Application Reference: 2024/0941

Site Address: 7 Meadow Lane, Darton, Barnsley, S75 5PF

This application seeks full planning permission for the Erection of detached garage to rear of single storey semi-detached dwelling, and erection of 2m high boundary wall.

Proposed Ground Floor Plan

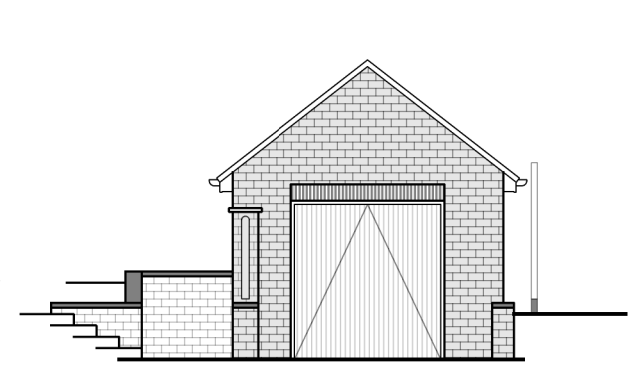
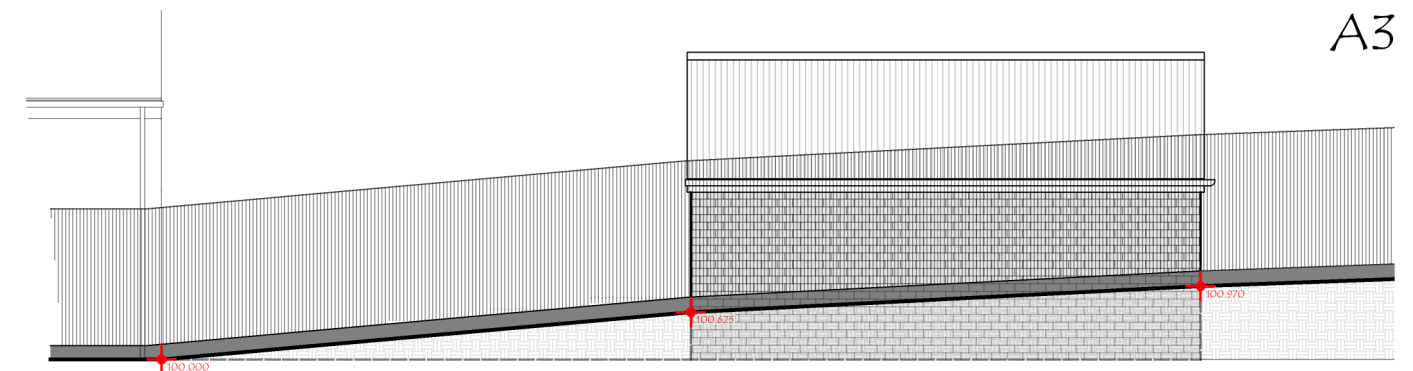
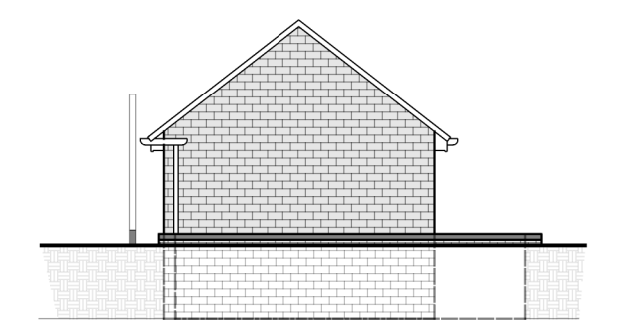
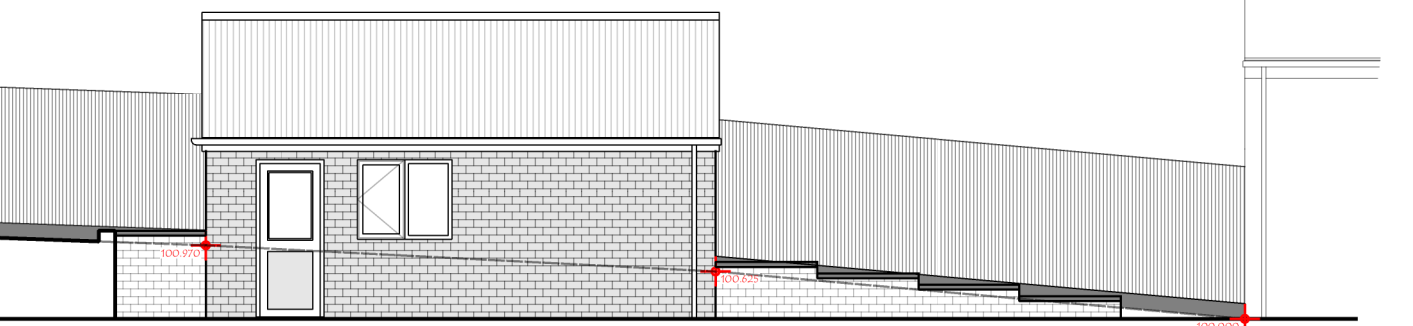
The principal aspect of the proposal is for the construction of a detached garage in the rear garden of the dwelling. The garage would be constructed of red brick and feature a tiled gable style roof. The garage is proposed to be set at the level of the driveway, which is lower than the natural level of the rear garden, as there is an incline from the front to rear of the dwelling's curtilage. The maximum height of the garage from the reduced ground level would be approximately 4m high, with an eaves height at approximately 2.3m. In context, the height of the existing fence is at an approximate constant height of 1.8m as it follows the contour of the ground level, whilst the garage would be between approximately 1.44m higher than the fence, reducing to 1.10m further into the garden. Excluding the retaining wall, the approximate

external width and length of the garage would be 3.59m and 6.74m respectively, whilst internal measurements would be approximately 3.09m and 6.24m respectively.

As the proposal is situated close to the boundary, then the most pertinent issue is how much impact the proposal would have in its proposed location instead of approximately 1.70m further into the applicant's garden, given the 30cm distance from the existing 1.8m high fence. With the garage set at a lower than natural ground level, even at approximately 4m high, the visible and subsequently impactful height of the garage from the neighbours' perspective would be a

maximum height of approximately 3.24m reducing to 2.9m further into the garden. The figures stated are based upon the approximate garage height above the 1.8m fence of 1.44m at the highest point reducing to 1.10m at the lowest. It would be considered that the impact of the proposed garage, would have a modest impact on the amenity of the neighbouring dwelling at No 9. In contrast the proposal would have limited impact on amenity of other neighbouring dwellings.

Site Plan 1:500

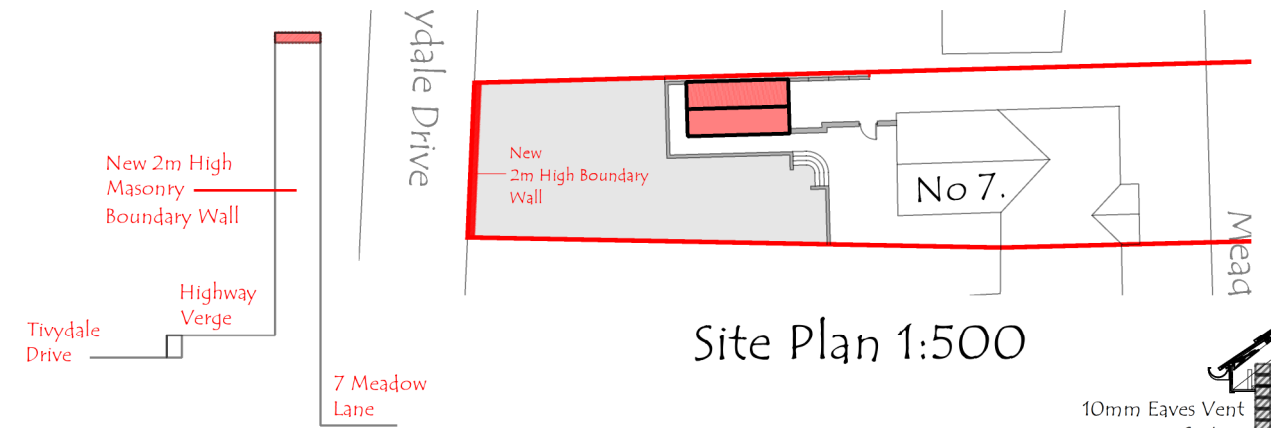
Additional aspects of the proposal are for a retaining brick wall built around the garage to compensate for the lower setting of the garage. The highest point of this wall seems to be 2m on the front elevation of the garage, with other sections of the wall much lower and below the height of the original fence. A 2m high rear boundary brick wall is proposed to be erected at the rear dwelling's curtilage where it borders Tivy Dale Drive. This would be constructed of matching red brick to the garage and feature supporting pillars. The wall would also be constructed behind the existing thinning hedgerow boundary treatment, which is proposed to be retained. The applicant has confirmed that other boundary wall or fence treatments would be equal or less to the maximum heights of boundary treatments allowed through permitted development, 2m at the rear and side of the dwelling, and 1m around the front garden.

Undoubtedly the scale of the proposed rear boundary wall would have a visual impact on the neighbouring dwellings on Tivy Dale Drive, but it is proposed to be constructed with supporting pillars and behind the existing hedgerow boundary treatment. With the supporting pillars and retention of the existing hedgerow the potential visual disparity and impact of the proposed wall would be diffused whilst also improving privacy and security of the applicant's dwelling. On balance, with the existing hedgerow diffusing the view of the wall, it would be considered that the proposed wall would have little or no impact on the application dwelling itself but a moderate impact regarding scale, design, and character of Tivy Dale Drive.

Whilst it is believed that the 2m high rear boundary wall would have a moderate visual impact to residents of Tivy Dale Drive, due to the height of existing boundary treatments with rear dwellings of Meadow Lane, It would be considered that the proposed wall would have little or no impact on the residential amenity of dwellings on Tivy Dale Drive.
